## Application for a Non-Material Amendment Following a Grant of Planning Permission

To establish whether amendments to the site layout for the electric vehicle charging bays and jet wash bays previously approved under planning application 22/01163/FULL, within the area of land adjacent to, and adjoining, the forecourt of Laindon Service Station, Arterial Road, Dunton, Basildon Essex, can be considered as non-material amendments (23/00632/NMABAS)

The electric vehicle (EV) charging bays retained in the present location as consented under Non Material Amendment planning application 23/00632/NMABAS, with principally only the jet wash bays being bought in front of the rear building with the associated equipment re-arranged and re-located to suit.

| Scale: 1:100 | | Dwg No: WPS-MFG-104-P-32 | |

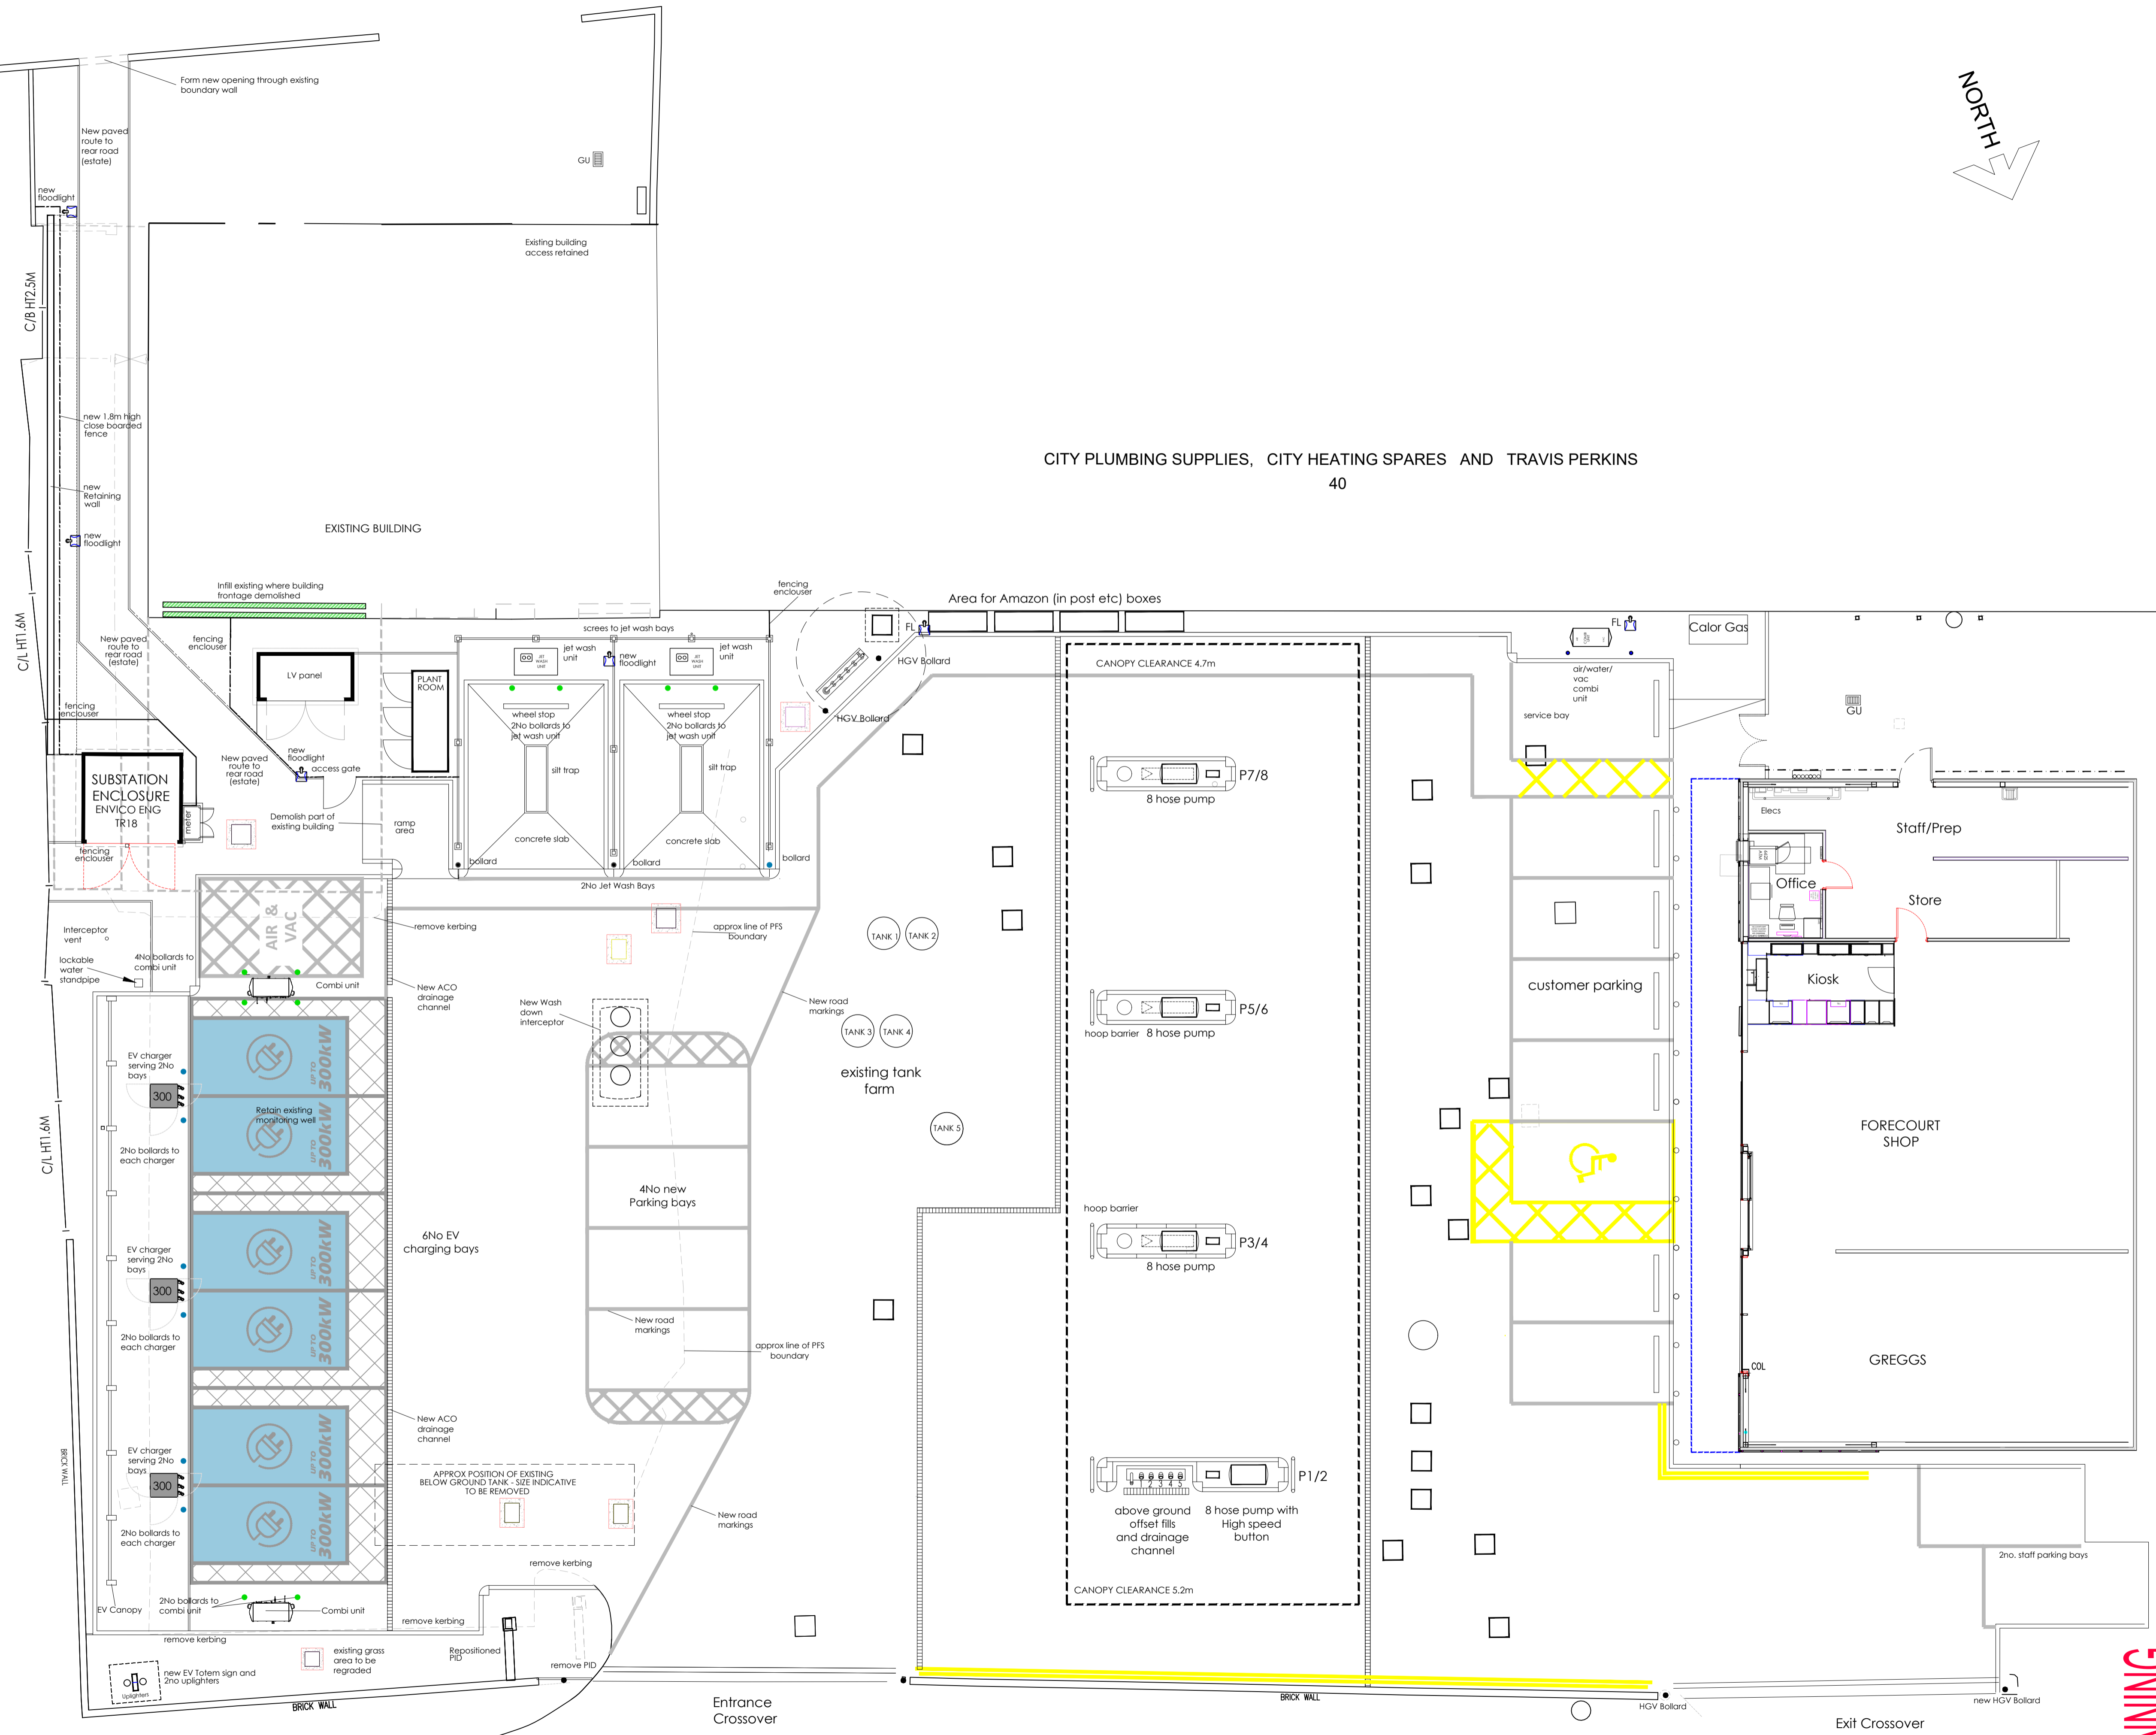
The part of the building previously intended for demolition under the current variation consent will be impractical to be removed.
